## ***Rezoning Petition Review***

**Rezoning Petition #:** 21-015

**Location of Property:** Approximately 2.56 acres located at the intersection of West Blvd and Holabird Ln, east of Billy Graham Pkwy and west of Old Steele Creek.

**SKETCH PLAN PRIVATE ALLEY OPTION**

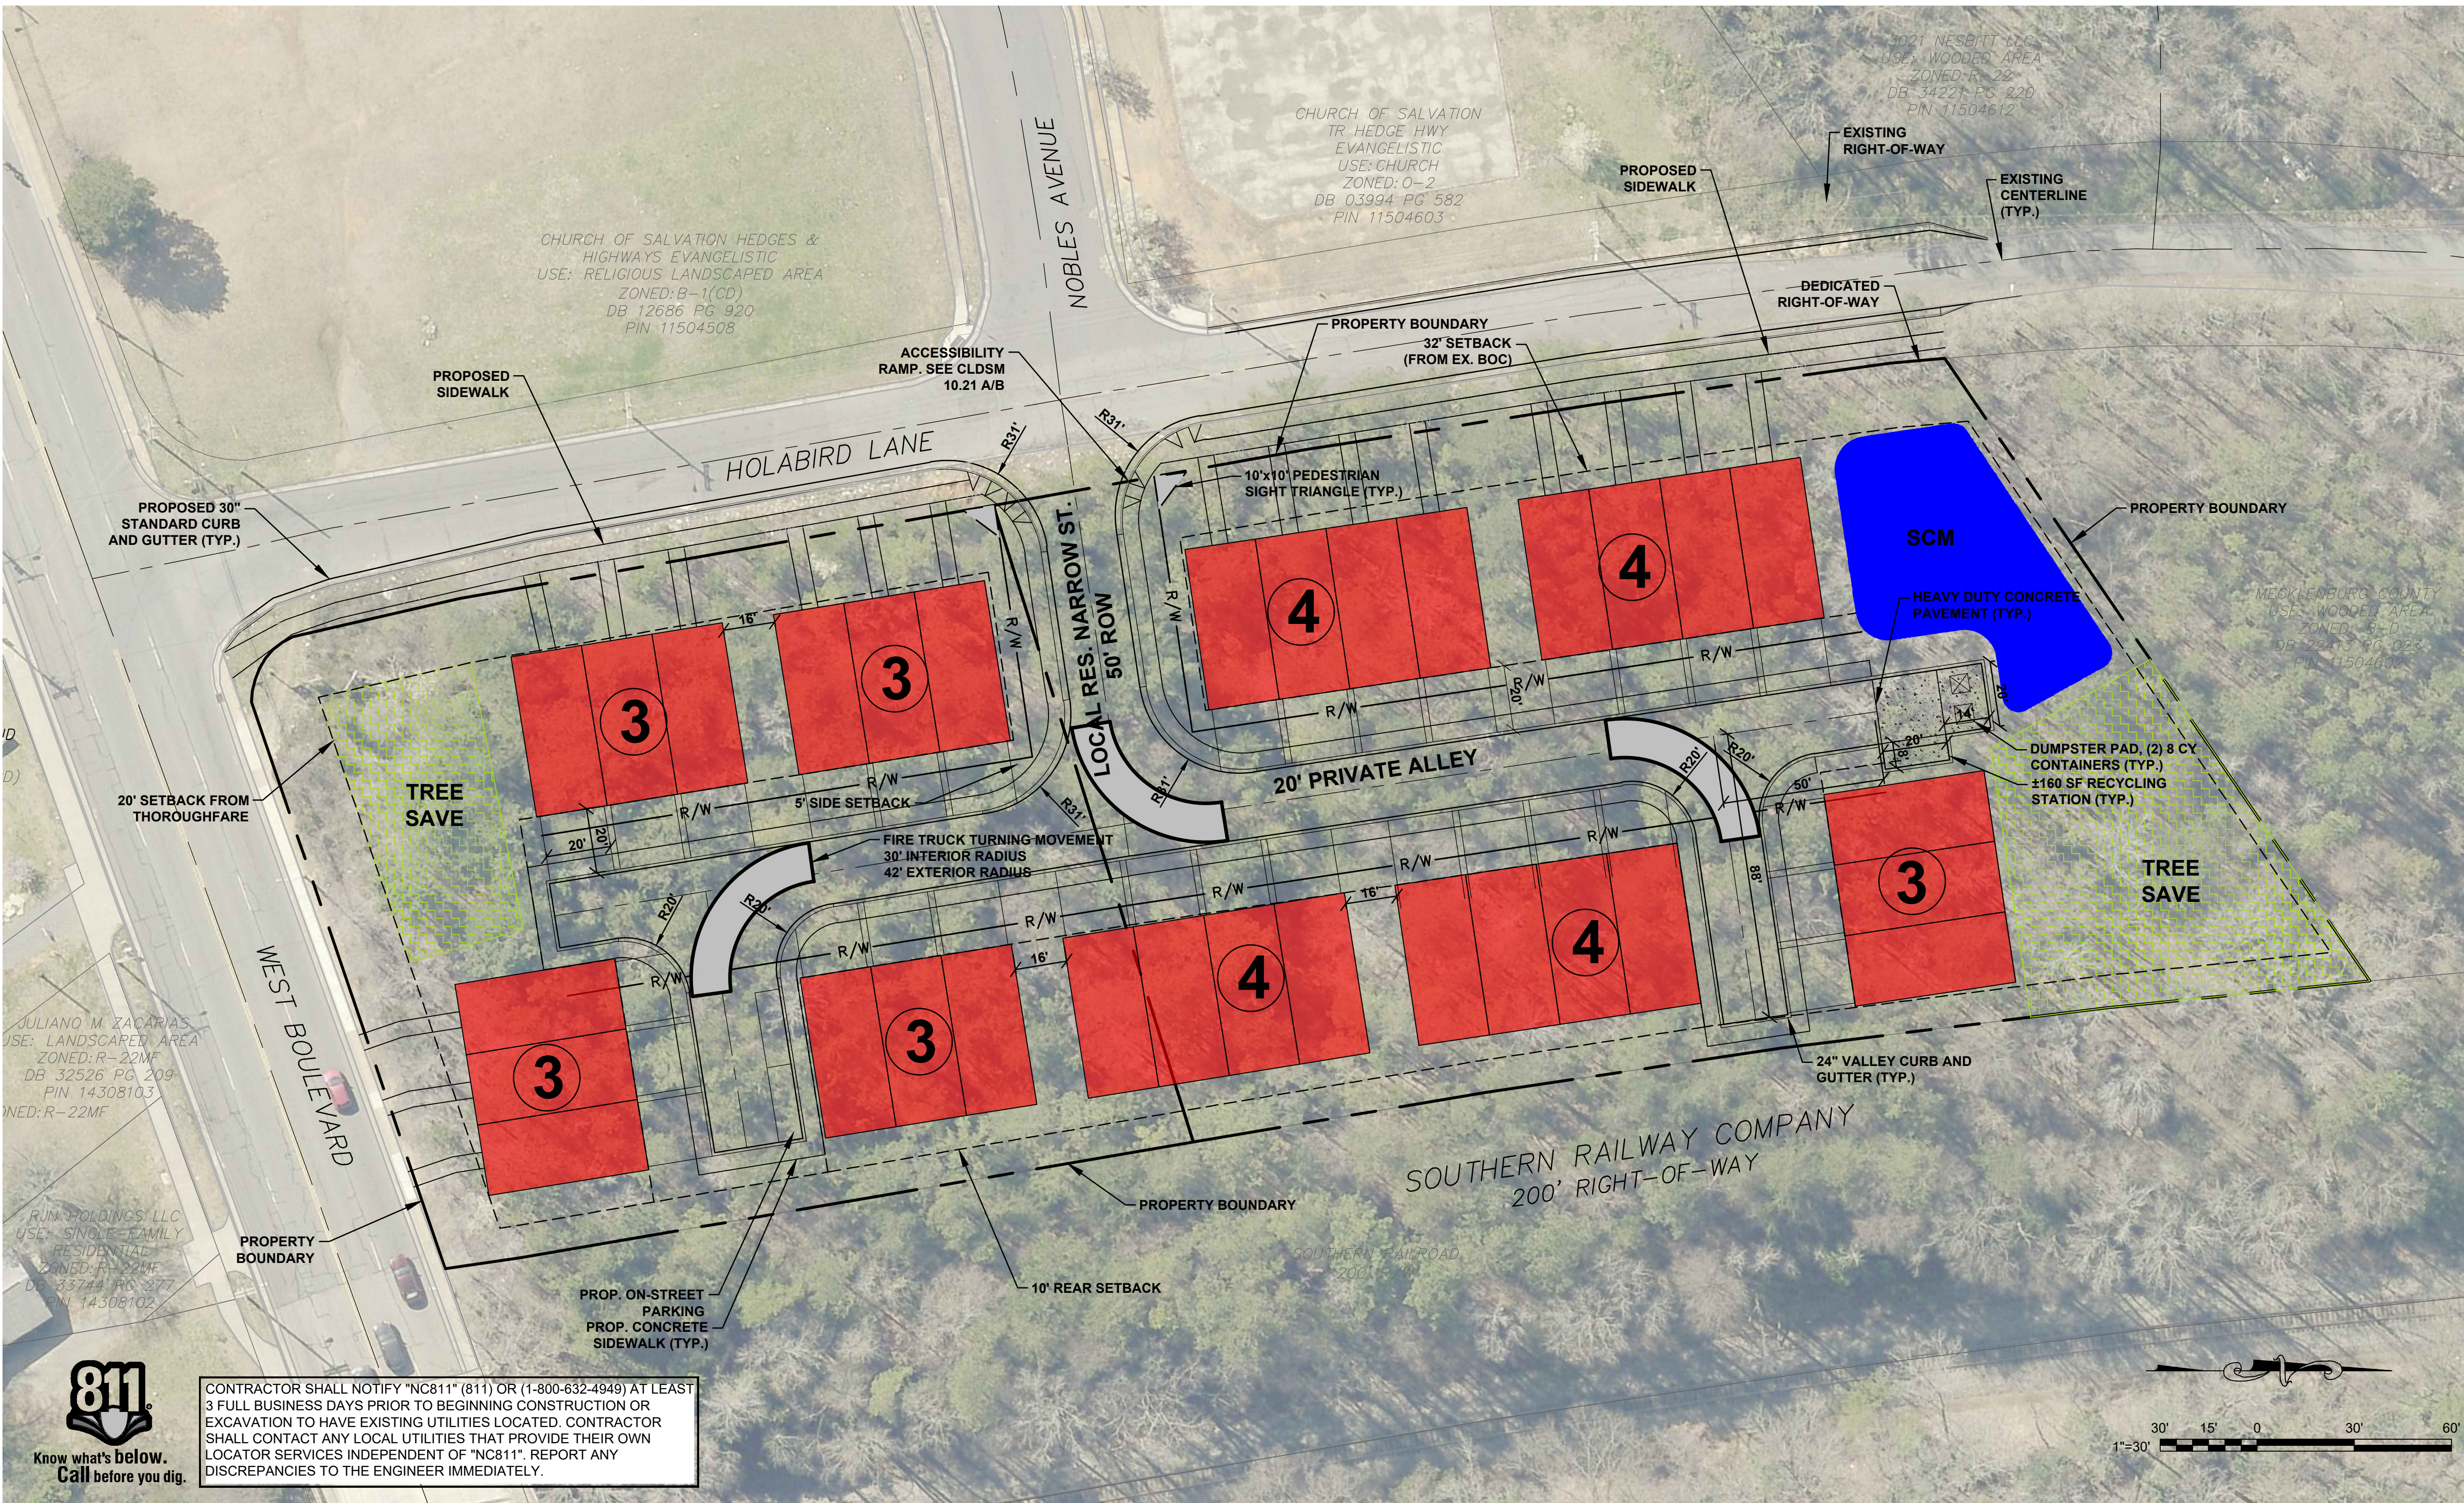
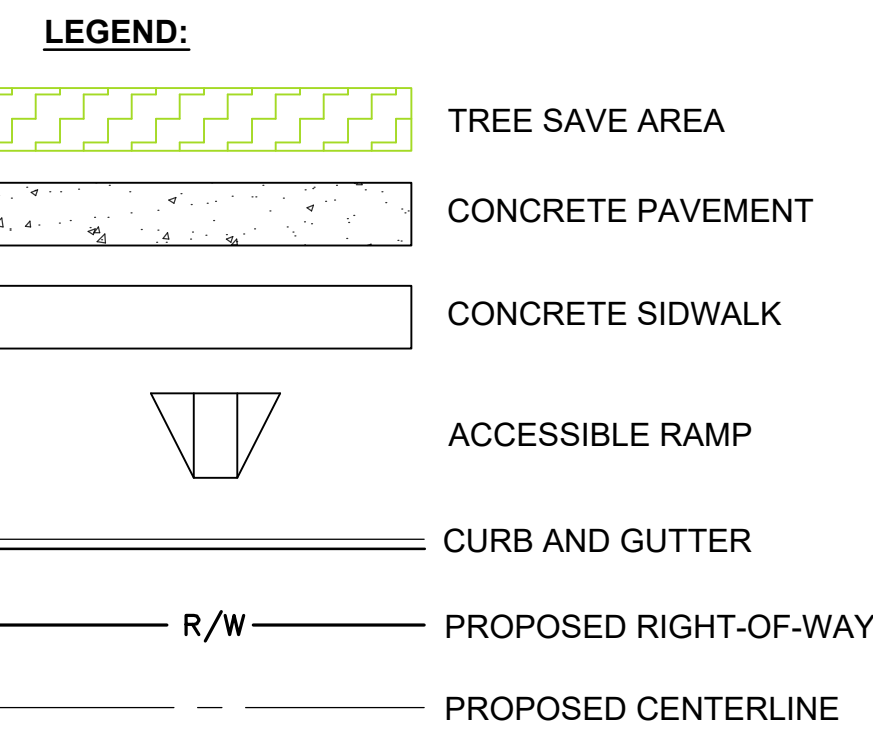
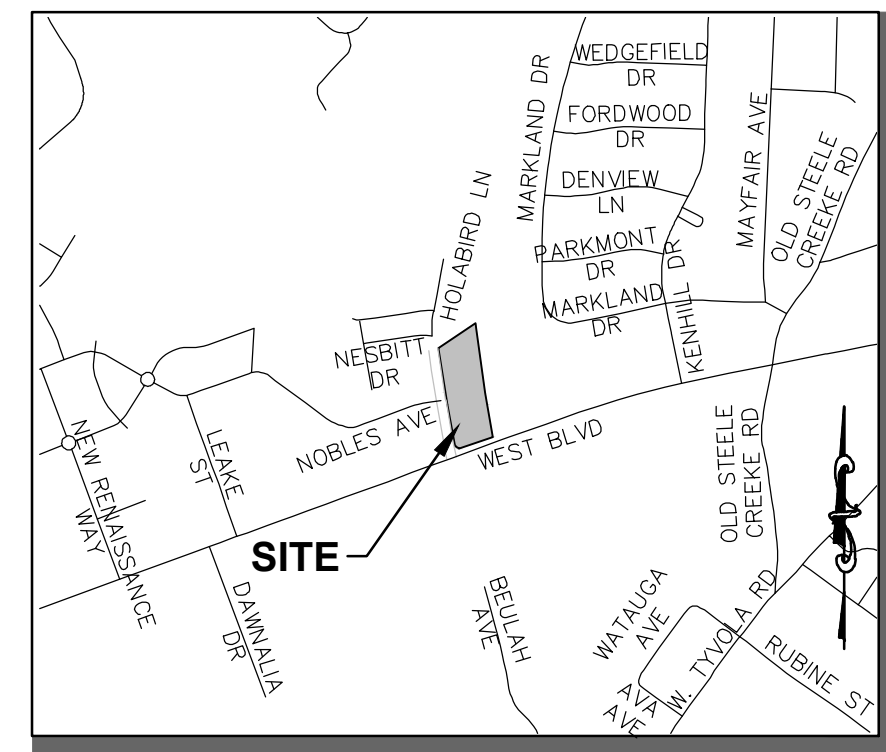
**Recommendations Concerning Storm Water:** The proposed rezoning plan sheet indicates a proposed location for storm water management. Please include the following notes on the plan sheet under "Environmental Features": *The location, size, and type of storm water management systems depicted on the Rezoning Plan are subject to review and approval as part of the full development plan submittal and are not implicitly approved with this rezoning. Adjustments may be necessary in order to accommodate actual storm water treatment requirements and natural site discharge points.*
